From: Jeremy Larson
Sent: Tuesday, February 4, 2025 2:52 PM
To: Bradley Gasawski
Subject: RE: SP-25-00001 Graf - Notice of Application

Thank you for the opportunity to provide comment on this short plat application.

GRAF SHORT PLAT

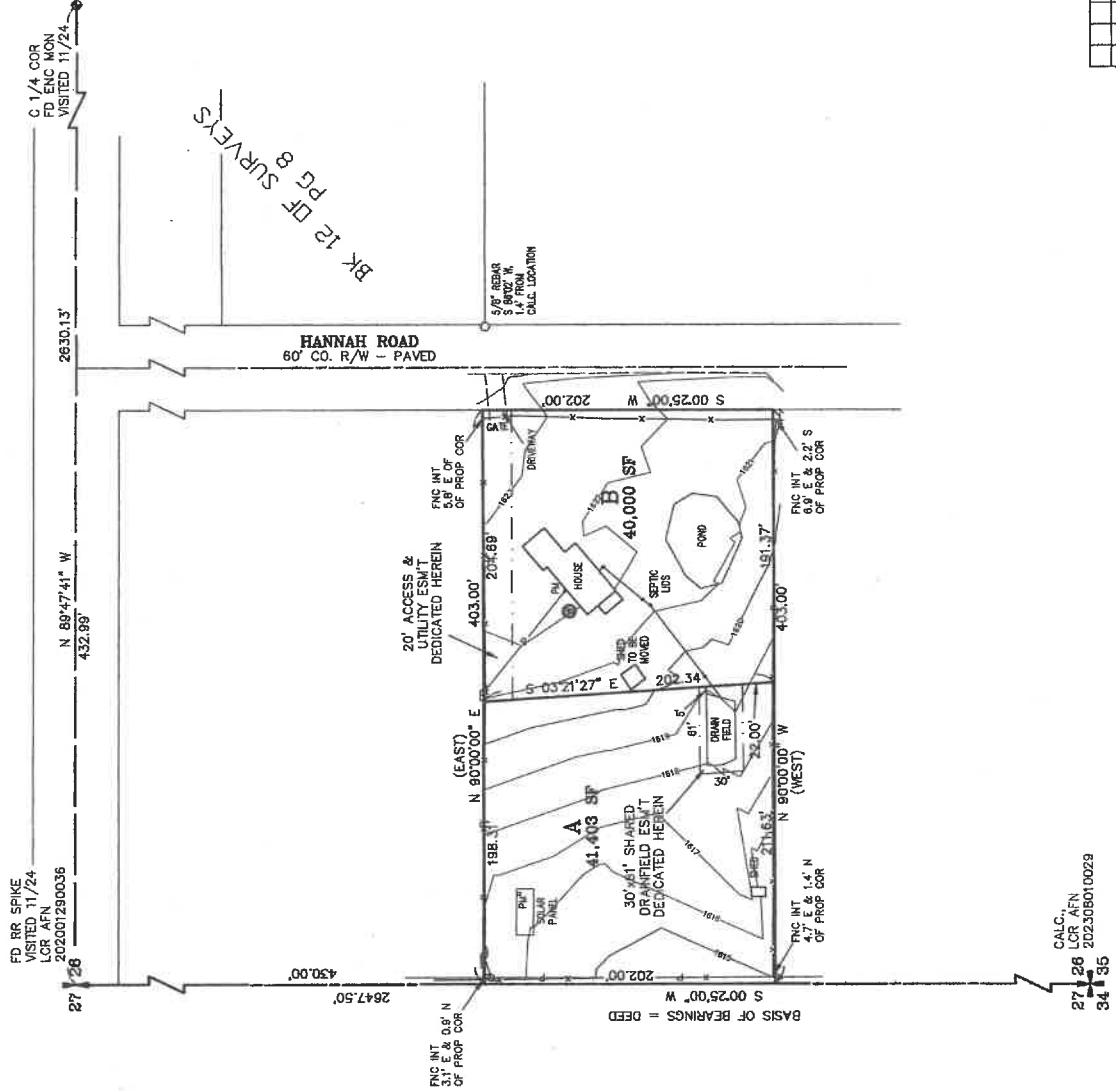
The site plan provided appears to show a corner of an existing shed on the proposed parcel boundary line. The note states "Shed to be moved." The shed would need to be moved prior to the short plat to remain compliant with the Fire Separation requirements of the Washington State International Residential code. Additionally, if the shed is over 200 square feet and/ or contains any habitable space, mechanical systems or plumbing, a building permit would be required to relocate the structure.
